**Bank Street Park Mod 2 (SSD-53386706-Mod-2)
 Response to Submissions**

This letter has been prepared by Architectus Australia Pty Ltd (Architectus) on behalf of Infrastructure NSW (INSW) in response to matters raised by the NSW Department of Planning Housing and Infrastructure (DPHI) in the letter dated 18 December 2026 for the proposed modification to Bank Street Park (SSD-53386706-Mod-2).

5 ELEVATION 01 - MARINA BUILDING (EAST).
1:50

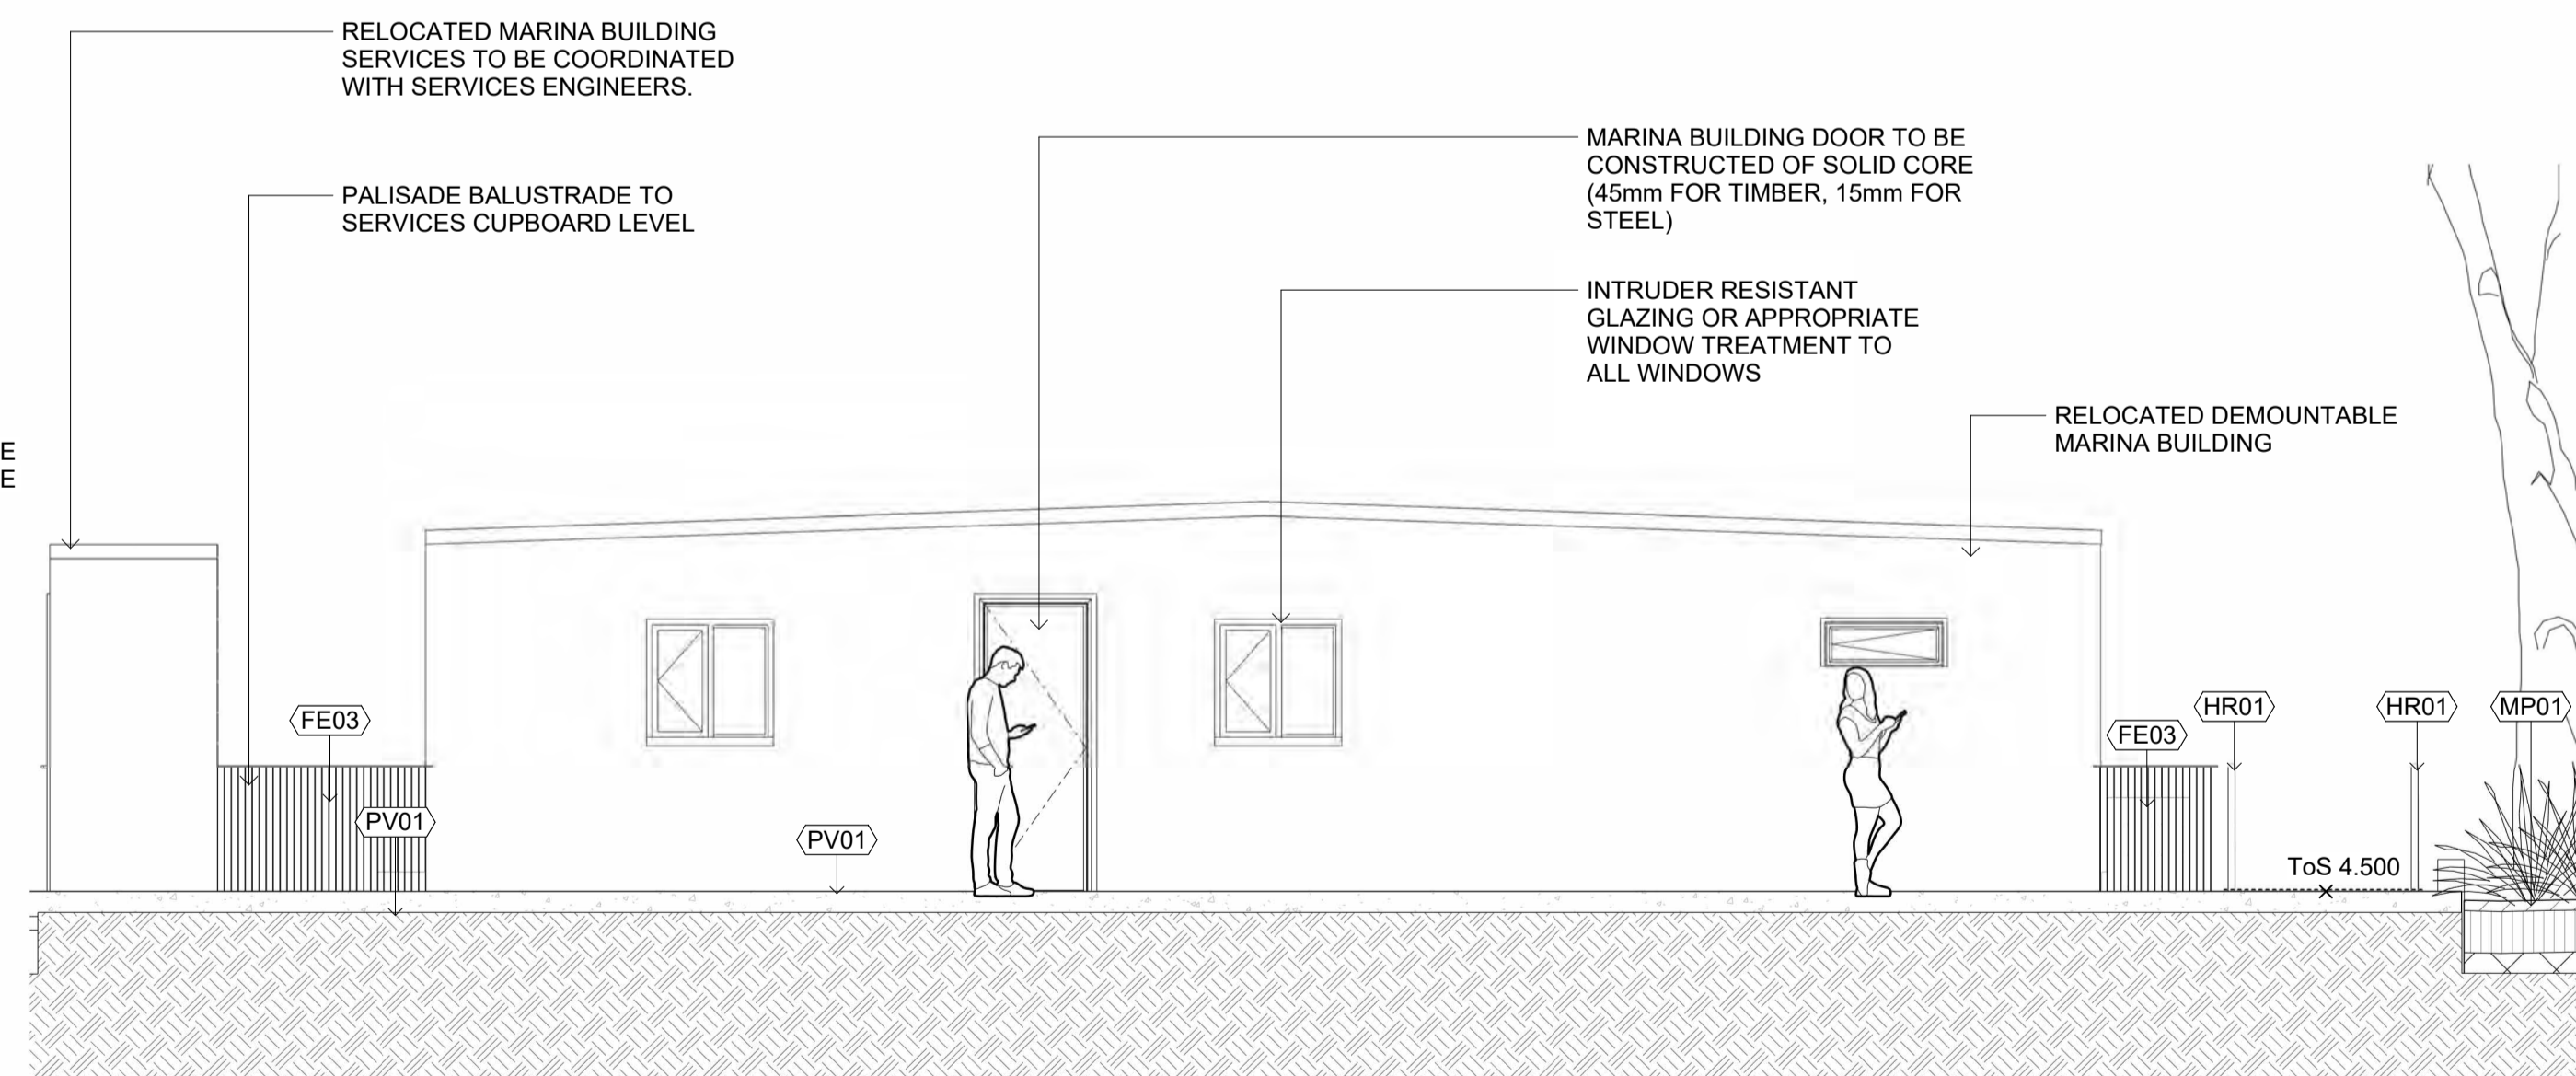
DPHI raised concern regarding fencing surrounding the new community building, including that this would unreasonably segregate marina functions and reduce integration given the open nature of the public park.

In response, fencing has been removed from the proposal as detailed in the marina building plans at **Attachment C**.
